North Wales Wind Farm Connection

Deadline 9 Representation based on my Open Hearing Dec 9th Statement

Robin Barlow BSc(Physics), PhD(Theoretical Physics) (Your reference: 10031190)

Figure 14.1 Position of wires (red) and earth wire (green) used for EMF calculations.

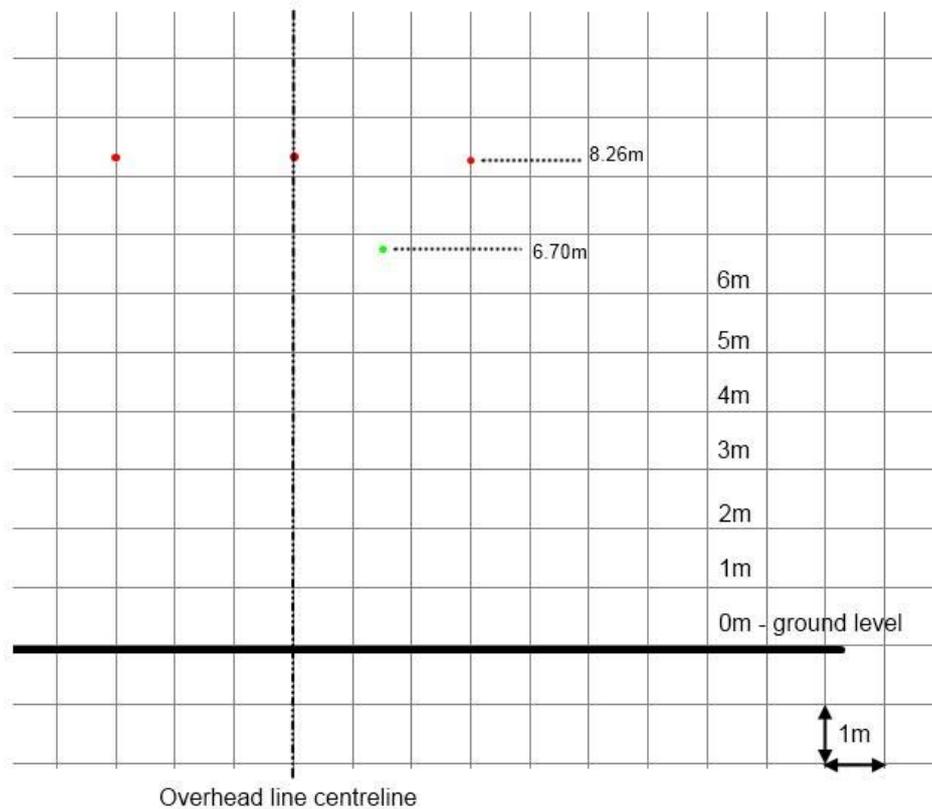
The Earth

The earthing issue is important because it makes the difference between using HDWP and Trident. It is not the twin poles of HDWP that is the big visual element (Mr Westmorland-Smith always emphasises the poles). It is the huge superstructure !

The reason quoted for not earthing at the Clocaenog substation is the extremely high ground resistance (another might be the cost advantage of having an earth rather than a conductor carry the telemetrics to St Asaph).

But, these appear to be isolated outcrops and the land nearby shows normal resistivity. It appears to me that SP Manweb has not studied this issue of earthing in any depth as their reply at the Specific Issue Hearing on 9th December (session 2) shows: "Don't envisage it to change enormously" (along the route! - at around 5-7 minutes of the recording). Perhaps the substation could have been sited at a location at Clocaenog with lower resistivity? What area is need to be secured for this purpose ? Perhaps an earth could be run from Clocaenog to Denbigh substation, using existing cable paths and enclosed land there found to provide earthing. I personally think that issue requires an independent desk-top study by a qualified external company.

I will keep it to a minimum. Again, to summarise, the reason quoted for not earthing at the Clocaenog substation is the extremely high ground resistance.

The British Geological Society's map "DiGMap-Plus: resistivity" which I referenced in the submission to which this is an Addendum confirms that, but also (I now realise) shows that the location of the Loch Urr 132KV substation is located in a more extensive region of even higher resistivity.

Given that SP Manweb have assured the hearing that the Loch Urr 132KV line does not carry an earth, one has to ask for the reasons and design differences between the two systems. I appreciate that the design proposed by SP Manweb for Clocaenog probably fits in well with their network concepts, but given that a large part of Denbighshire and Conwy countryside is going to be blighted by their solution, they should put some effort into thinking outside the box and outside minimum cost. Thus an explanation please with for example the Soil Resistance, the design of the earth grid potentially out to the enclosure, the earth grid resistance for that grid, the Earth Potential Rise, and the Step and Touch voltages for the two substations.

And, of course, it doesn't need to be a tower: the 132KV earth on the HDWP could be bonded at say the first 50 towers to an Earth cable running down the wood pole into the ground. After that revert to Trident and no earth ! But perhaps, not consistent with the line protection philosophy.
